Drawing
 Existing Site Plan with swept path

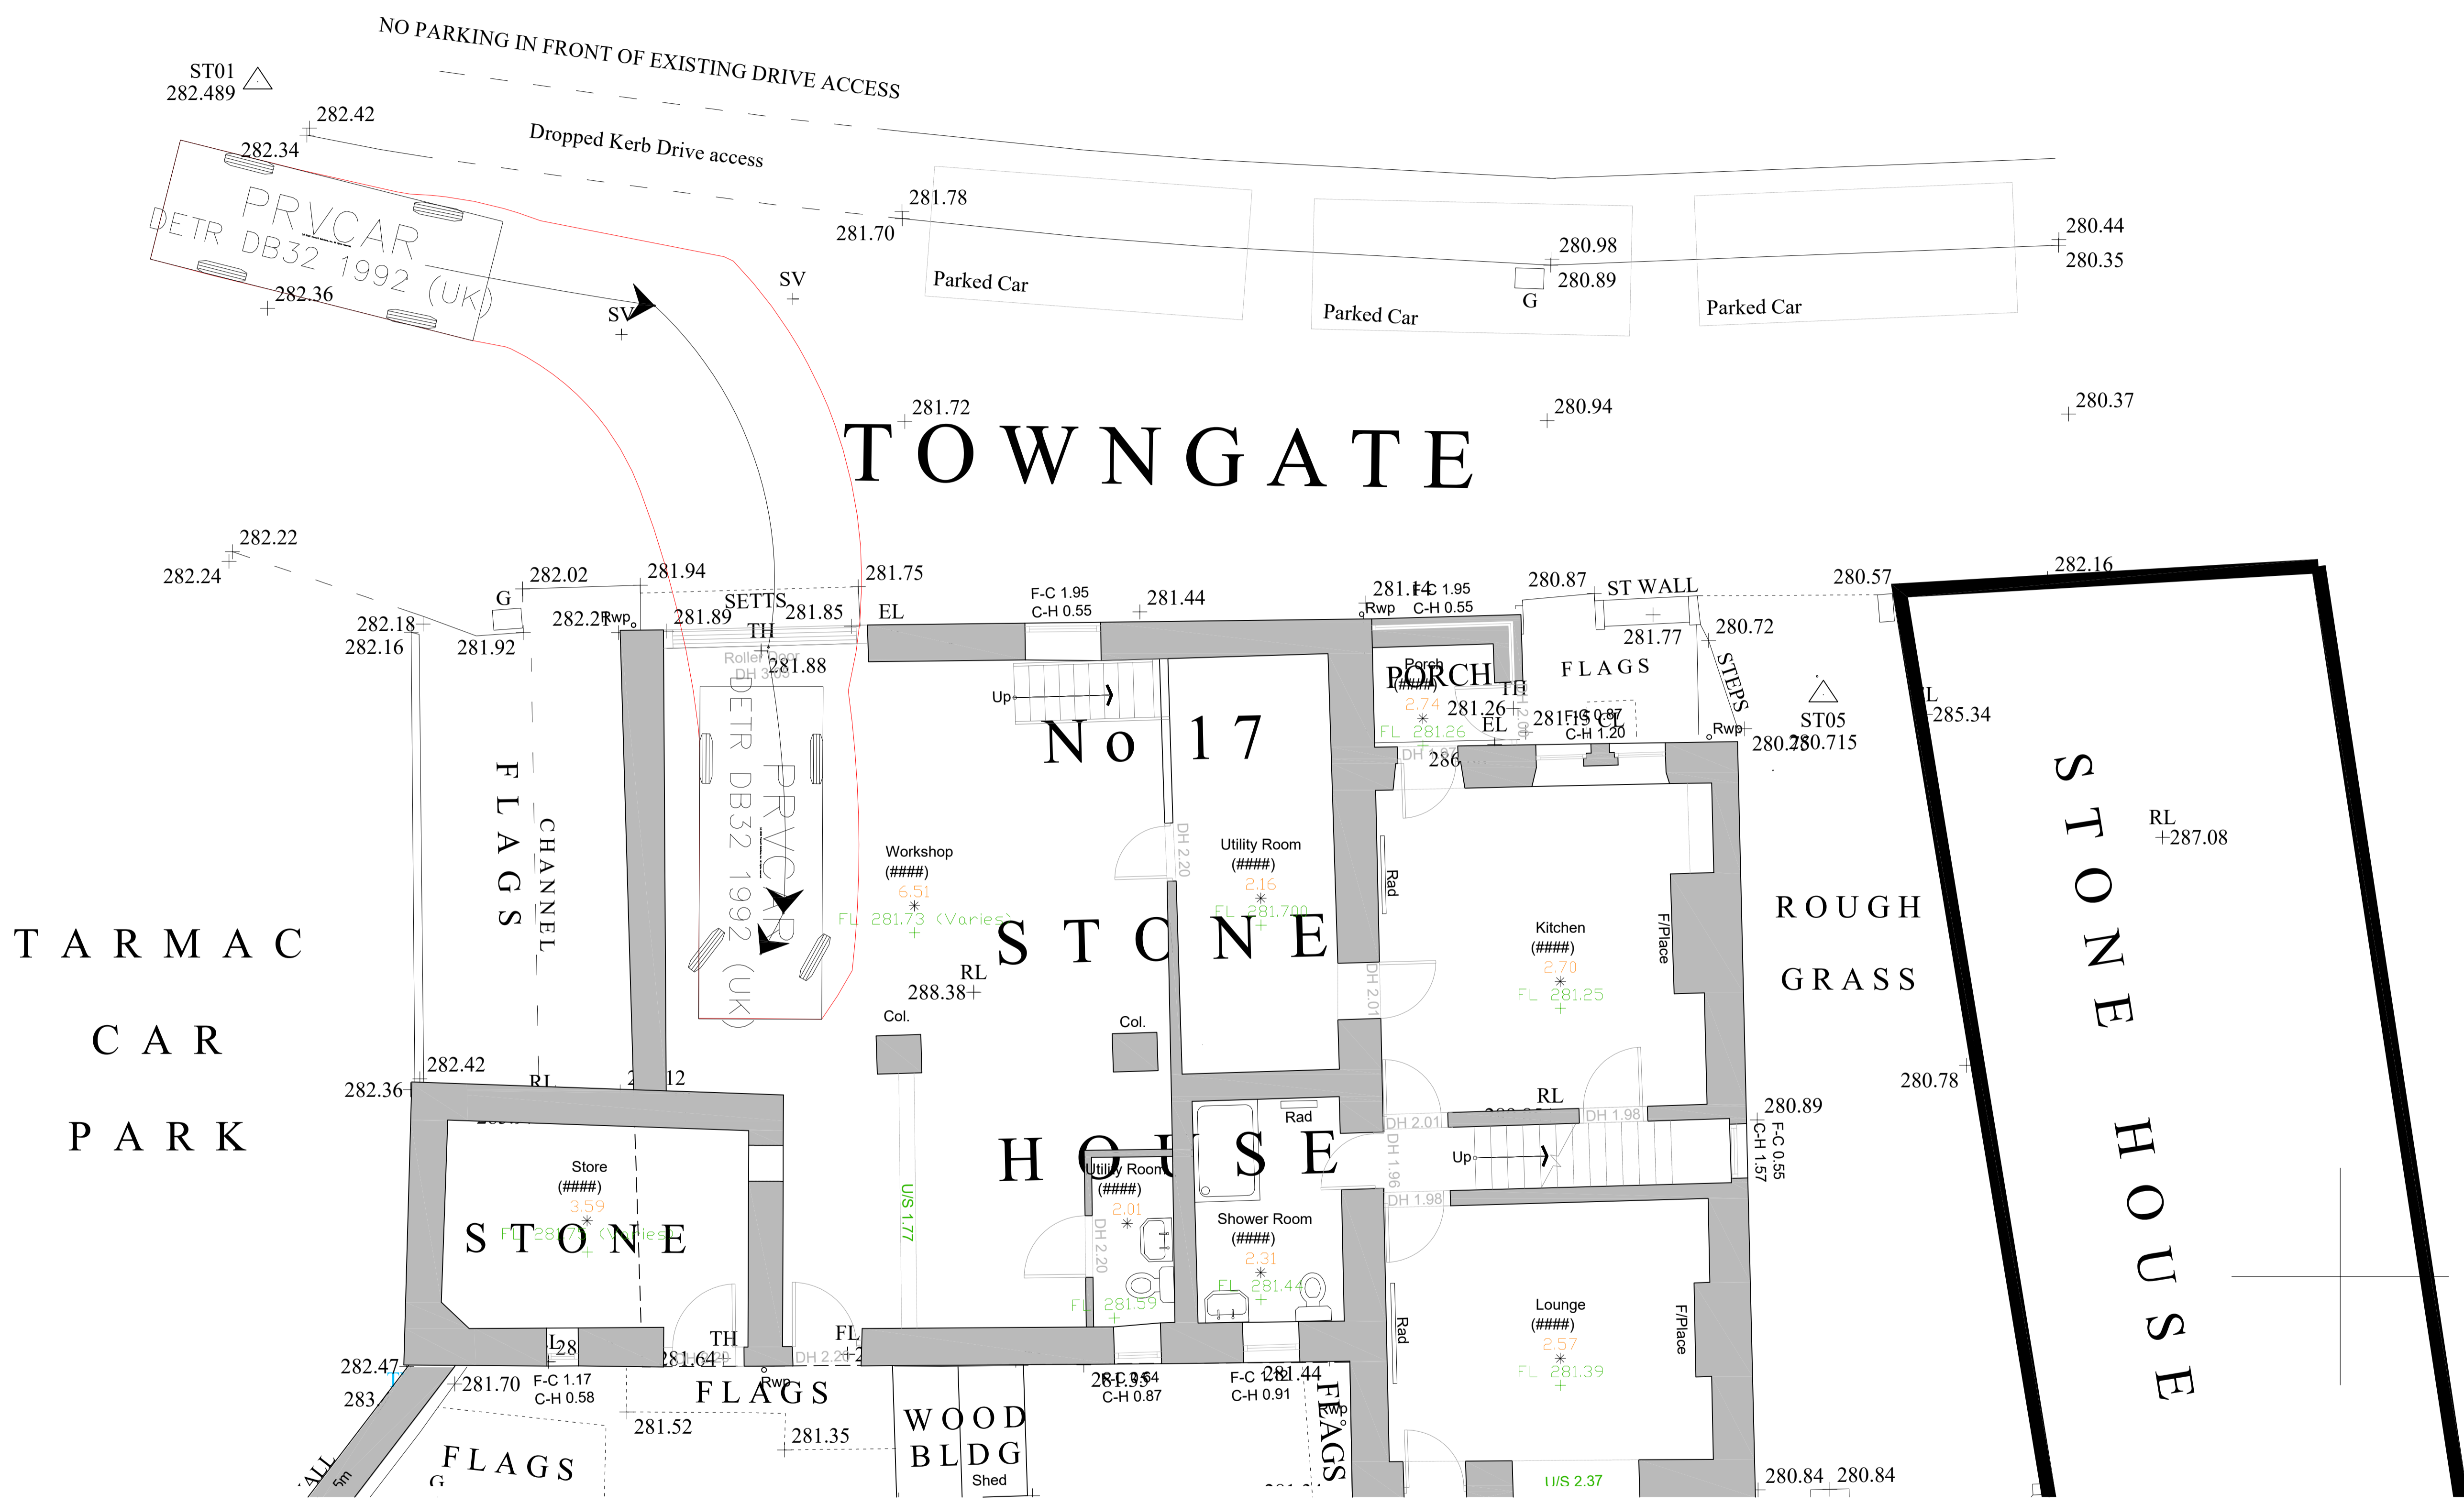
There would be particularly inadequate visibility for a vehicle emerging as proposed narrow archway onto Towngate. There is no setback without any footpath width available on this side.

The existing fabric offers only substandard width to drive through from street entrance to back garden (cars are getting bigger all the time). There is a wider open access on the other side of the house to the barn

17 Towngate Proposed Site Sections

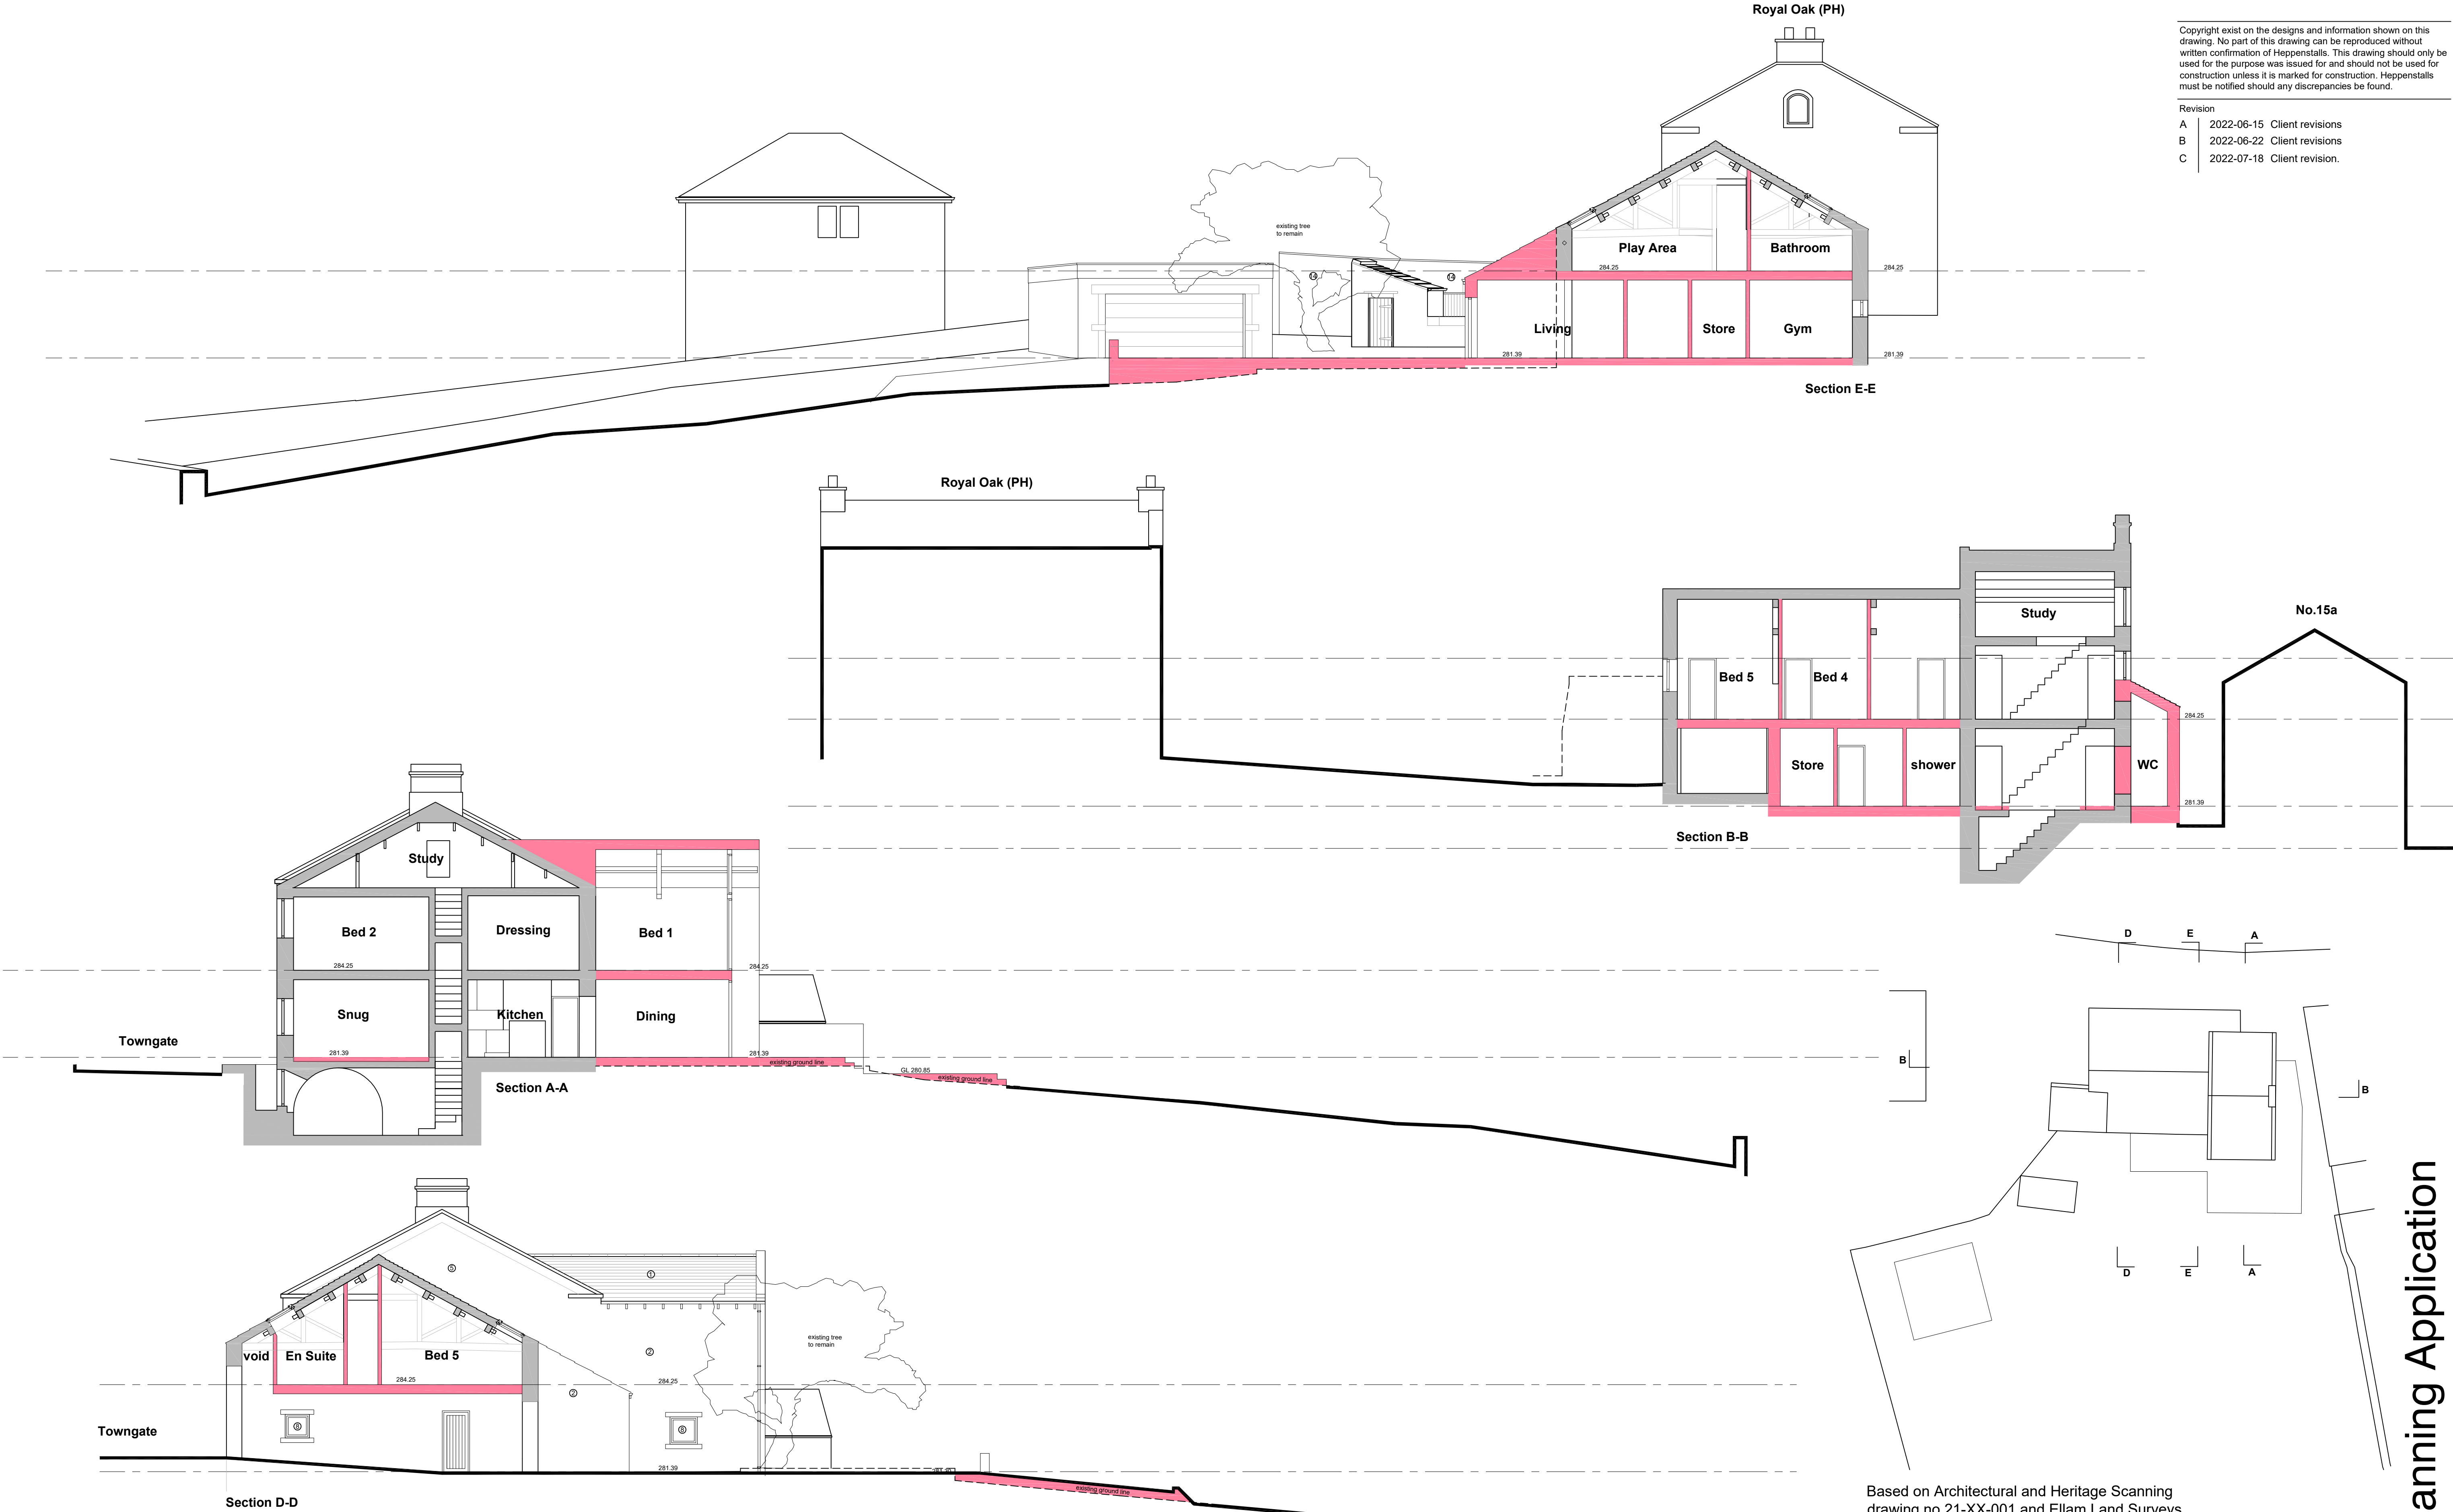
The unnecessarily-high boundary wall as proposed would be overbearing. Specifically, it would build up the skyline to the West of many homes and gardens below.
